001	Site Overview
002	Site Access Overview

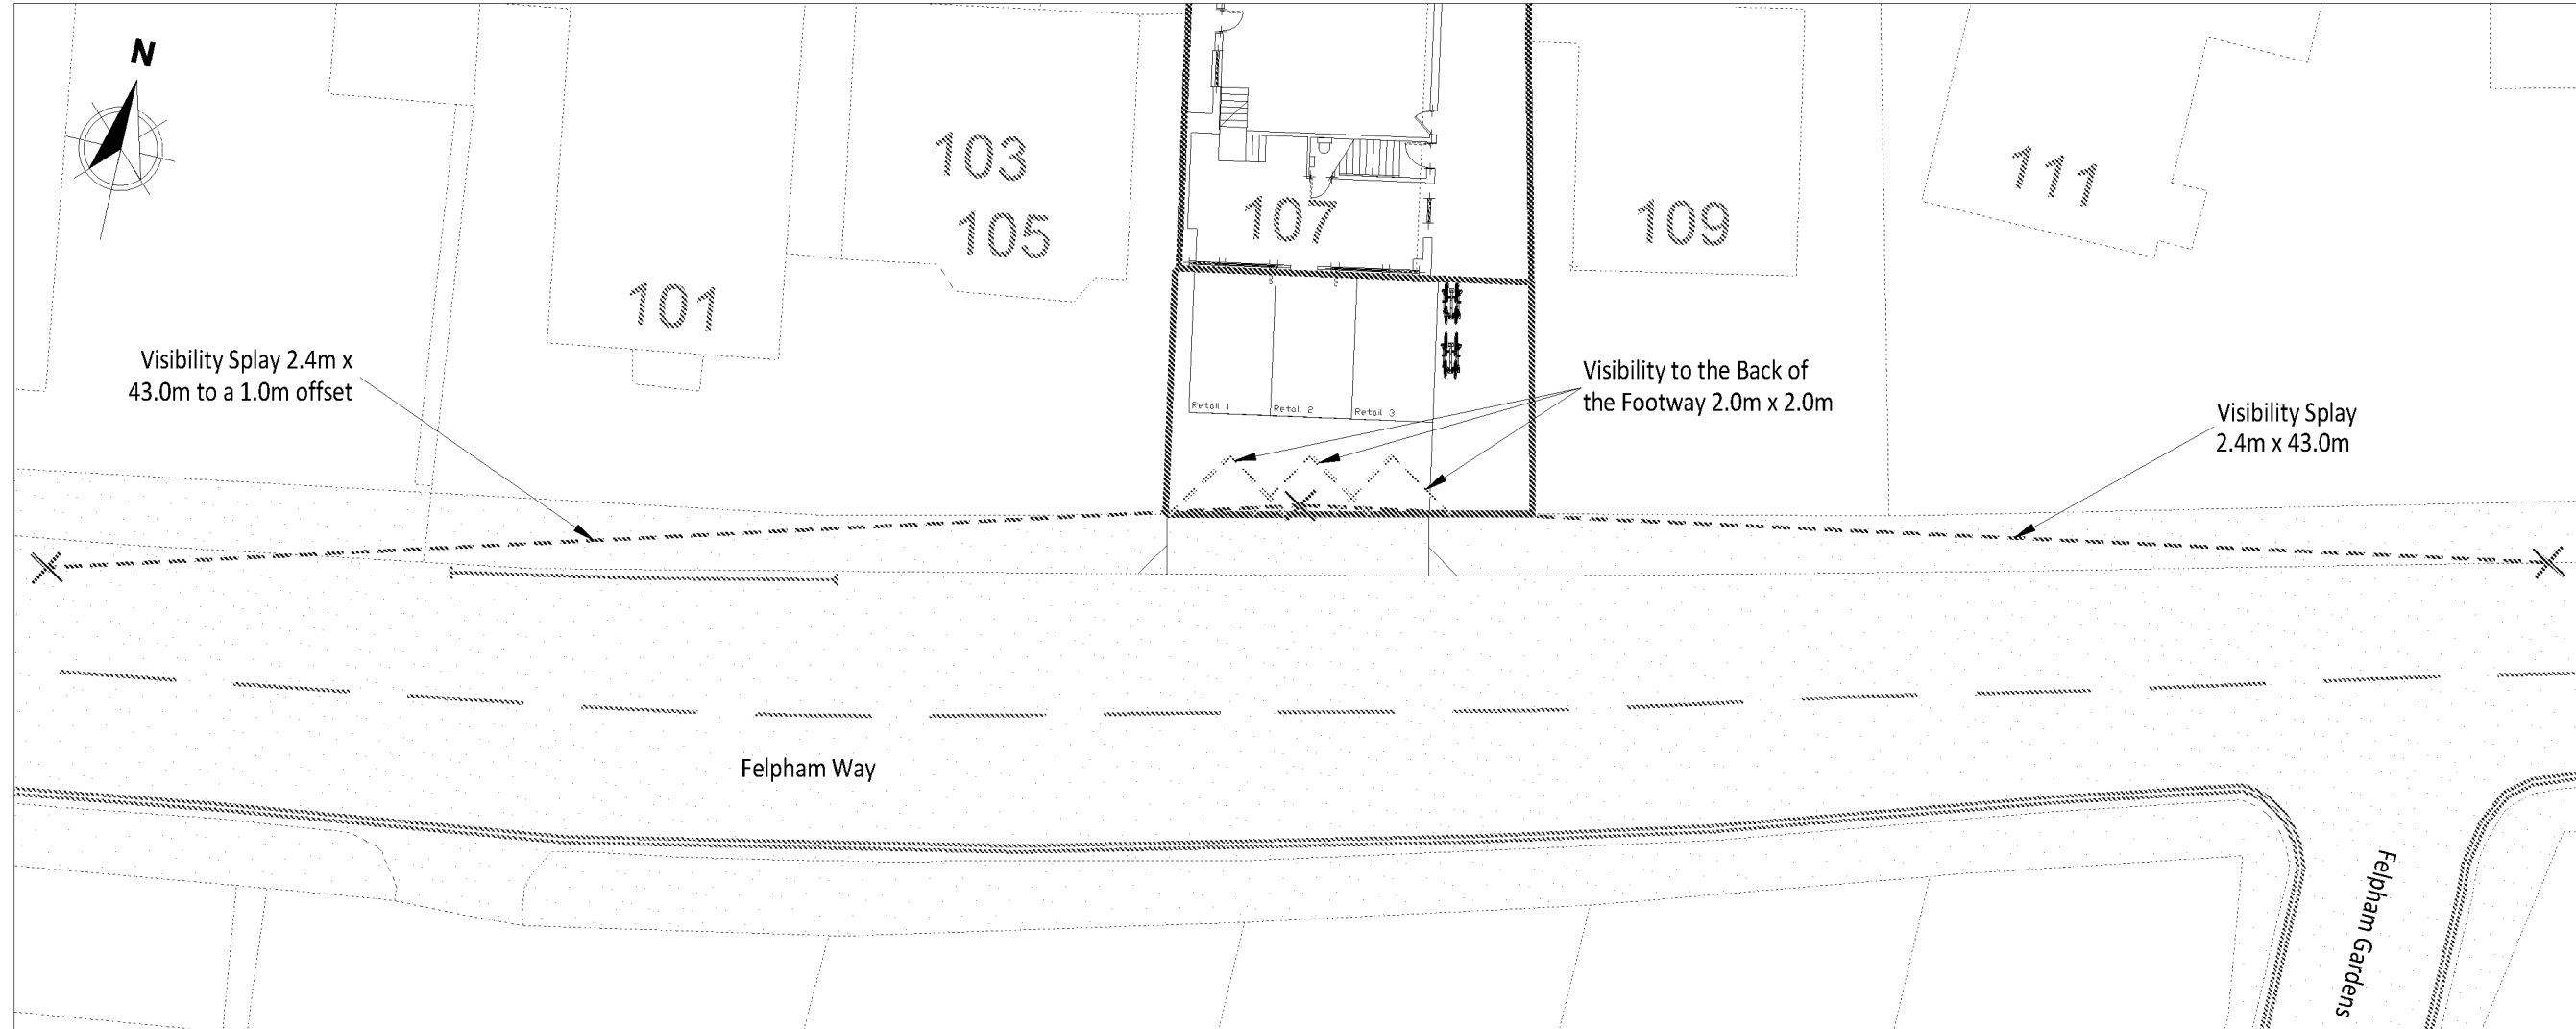
No worries about the confusion with the parking layout, I appreciate your comment that it is likely people have parked in this area previously. From a highway safety point of view, if the parking is to be retained then we would have no issue with this provided the dropped kerb is extended, as noted on your plan. I also think we could not object on a nil parking provision basis but which option you choose is up to you and dependent on the legal position, which I am afraid I can't comment on.

I think perhaps you have misunderstood my comments from 17/02. The two spaces at parallel arrangement were commented on as:

it could be challenging to manoeuvre into the parallel spaces entirely within red edge and may require use of neighbouring land

So as per these comments the spaces would probably not be accessible without using neighbouring land and neighbouring vehicle crossover and this was not stated as a preferred option. Therefore, if this is the design you wish to put forward you should demonstrate that they are accessible through swept path tracking or the LPA should be satisfied that manoeuvrability in and out of these spaces may cross third party land and that they are happy with these arrangements.

Ground Floor Plan - Proposed 1:100

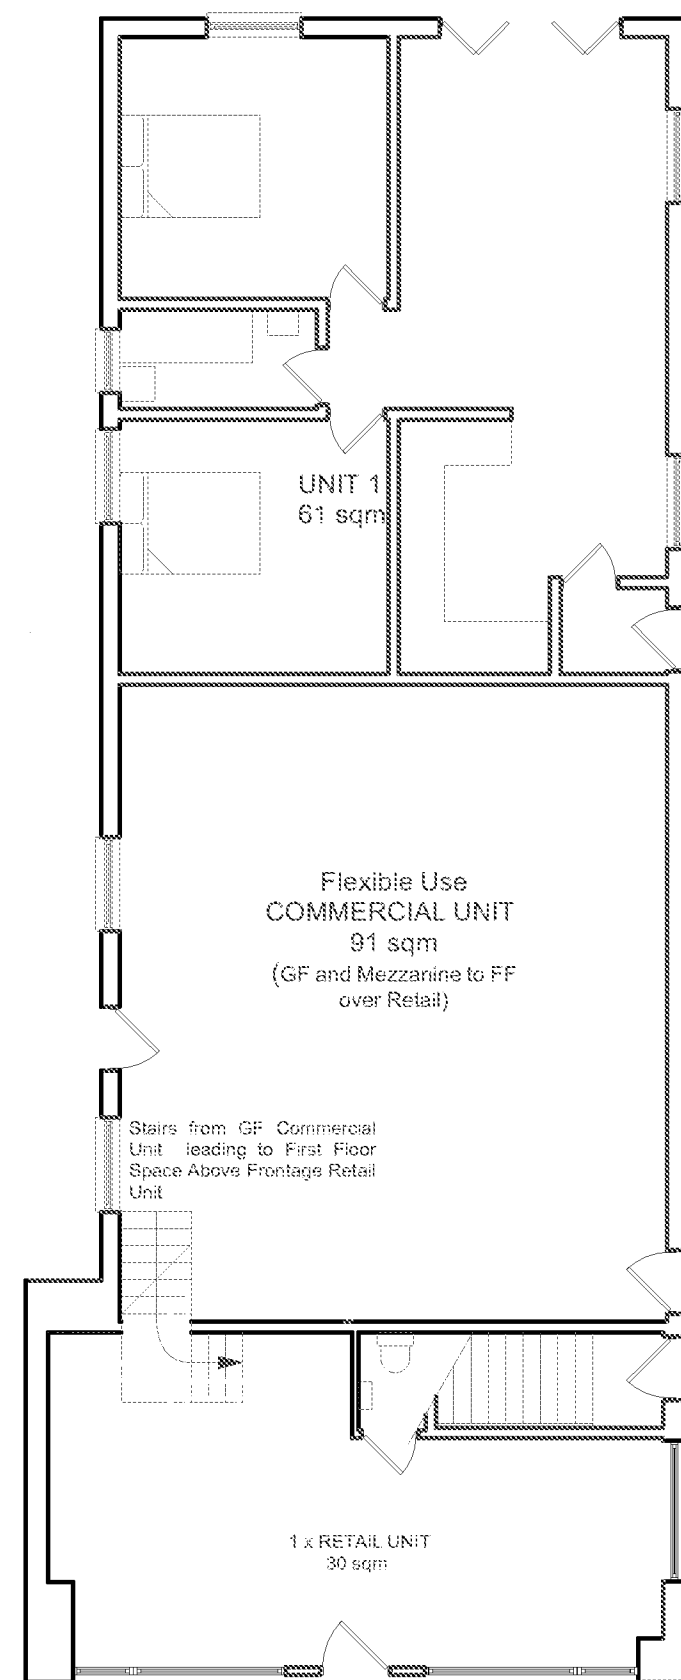
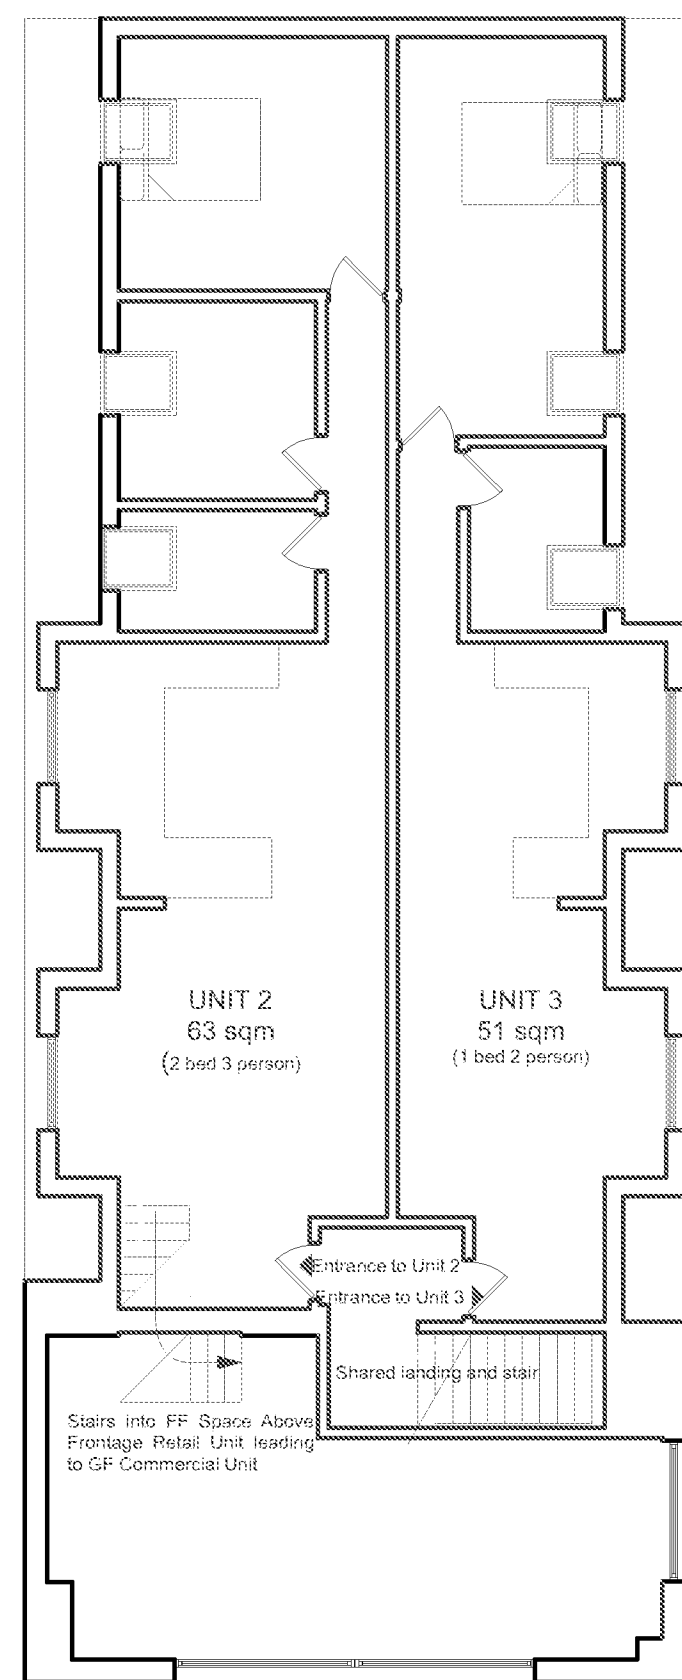
In your proposal you are opening proposed Commercial Unit to the west showing windows and door

to 1m deep 'yard' facing to the entrance of 15A with no access?

It would violate the privacy of the occupiers of that flat.

The proposed unit 1(ground floor would have a poor outlook from bedroom with a window facing to the wall

within a distance 1m what is not acceptable.

Unit 3 (first floor) habitable room windows on the eastern elevation (within a distance of approximately 3m from the flank wall of No 109

With habitable window at the first floor level; not acceptable. The proposed bedroom shows low level roof light with a possibility of overlooking the private garden of 109.

In addition the proposed bedrooms (Unit 2) would have only rooflights with no outlook.
